Nick Robertson  
6227 5<sup>th</sup> AVE NW  
Seattle, WA 98107.  
RE: 2009-003-SUB1- ZETTEL RESIDENCE  
6415 SE 24<sup>TH</sup> ST MERCER ISLAND 98040

Please see correction responses for **CORRECTION NOTICE #1- ORDINANCE/STRUCTURAL**

14 DECK GUARDRAIL
SCALE: 3/4" = 1'-0"

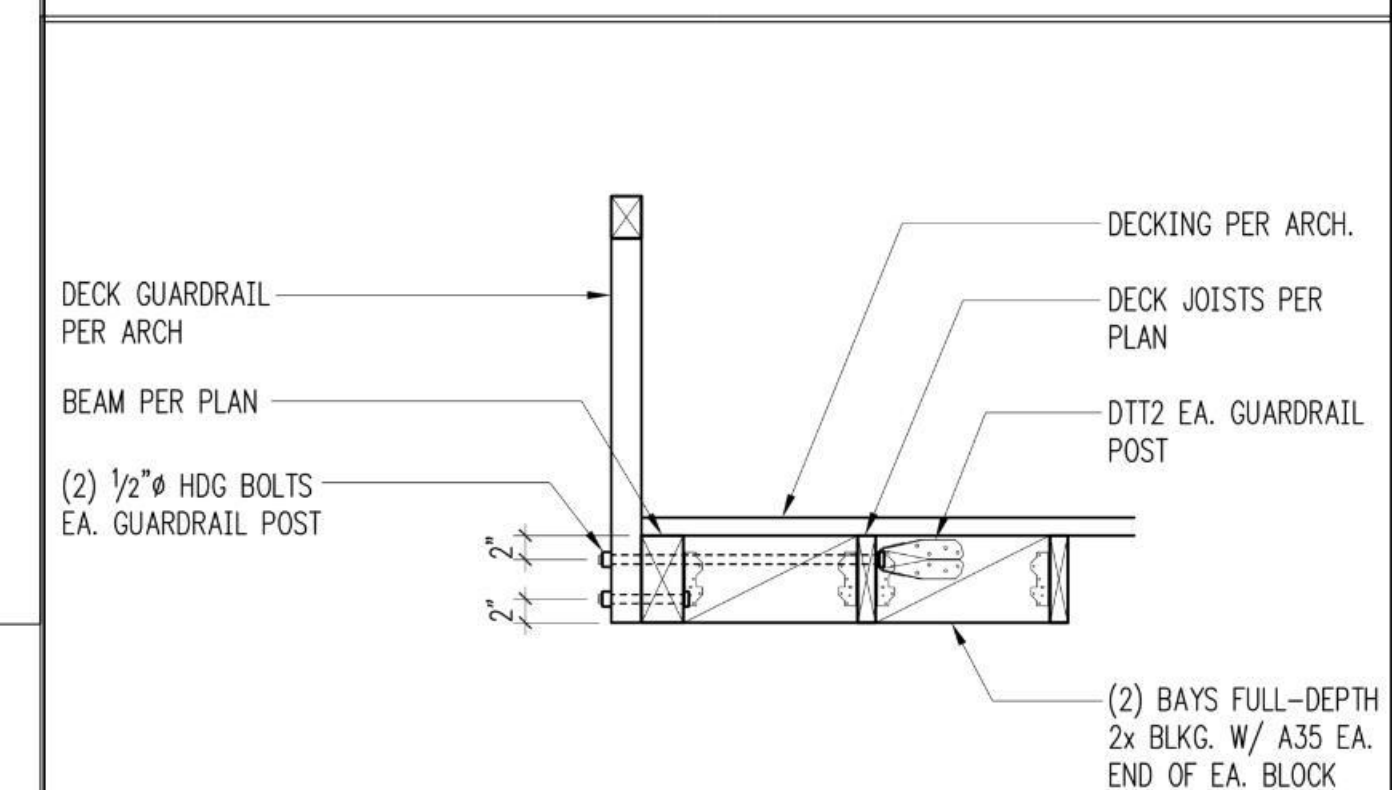
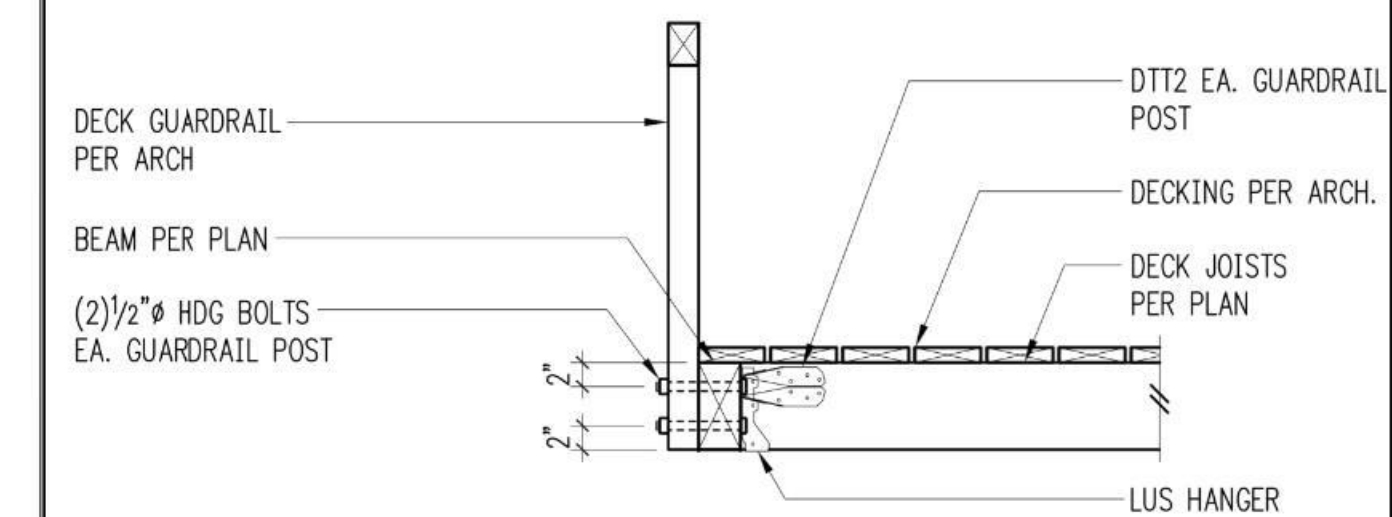
Provide a section where guard is attached parallel with deck framing.

Author: Building Review (paul.skidmore@mercergov.org) Subject: Comment Date: 11/27/2020 8:22:37 PM  
Include connection detail of guard. Alternatively clearly note on the drawings that the guard design shall be a deferred submittal, formally reviewed by the City prior to installation.

👉 Author: NICK ROBERTSON (NICK@STUDIOPIANONOBILE.COM) Subject: Date: 12/18/2020 5:39:32  
Sticky Note New detail 14 provides guardrail attachment to deck framing

Author: Subject: Sticky Note Date: 12/18/2020 6:04:00  
new detail 14 provides guardrail attachment to deck framing
